Recommendation Report for Planning Permission for Works or Extension to a Dwelling

REF NO: R/209/20/HH

LOCATION: 3 Wilton Drive
Rustington
BN16 3TG

PROPOSAL: Single storey rear extension including demolition of existing conservatory

Title: Proposed Plans LA017_010
Scale: 1:100
Date: 10/20

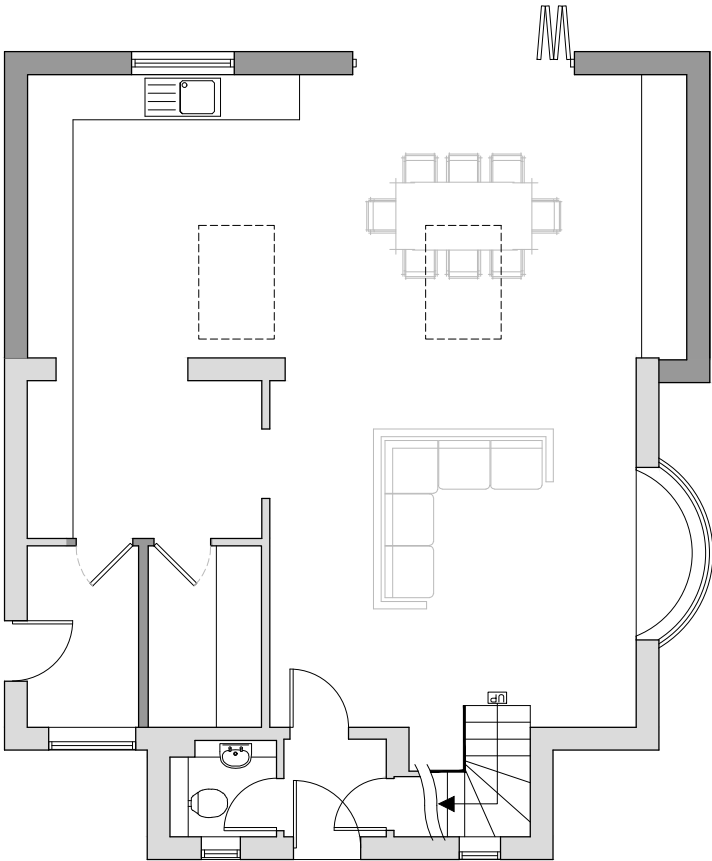
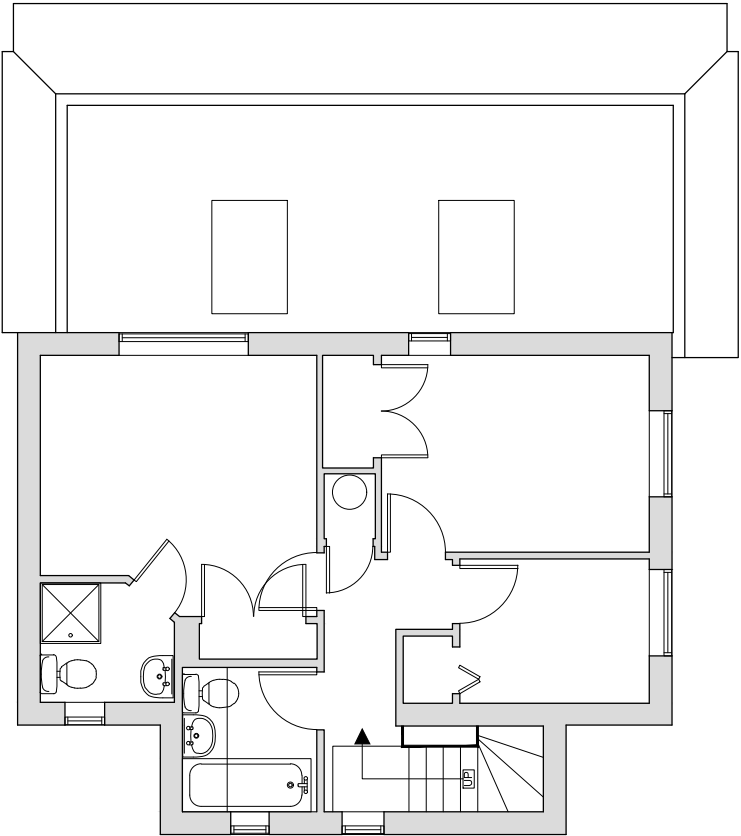
The proposed development has a maximum height 3.46m, which slopes down to the eaves height of 2.476m. Furthermore, it matches the existing roof slope of said host dwelling and utilises a palette of materials similar to the host dwelling. Resultant of these factors, the extension is considered to appear subservient to, and well integrated with the host dwelling.

Title: Proposed Site Plan LA017_030
Scale: 1:200
Date: 10/20

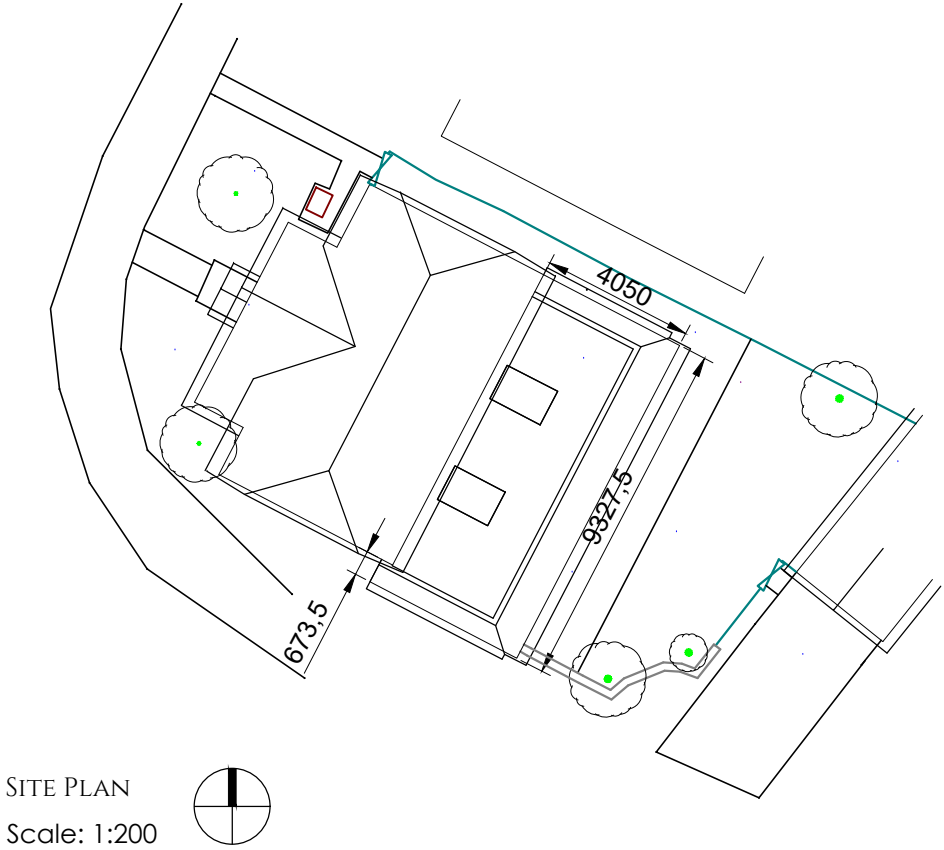
The proposed development is not considered to result in any significantly harmful overshadowing or overbearing impact upon the occupiers of neighbouring dwellings. This is due to the separation distance of 6m between the extension and the eastern application site boundary and the boundary treatment between the dwellings mitigating any significantly harmful impact. With regard to loss of privacy, the proposed development is single storey in its nature, and as such, does not provide any views that are not available from the application site at current.
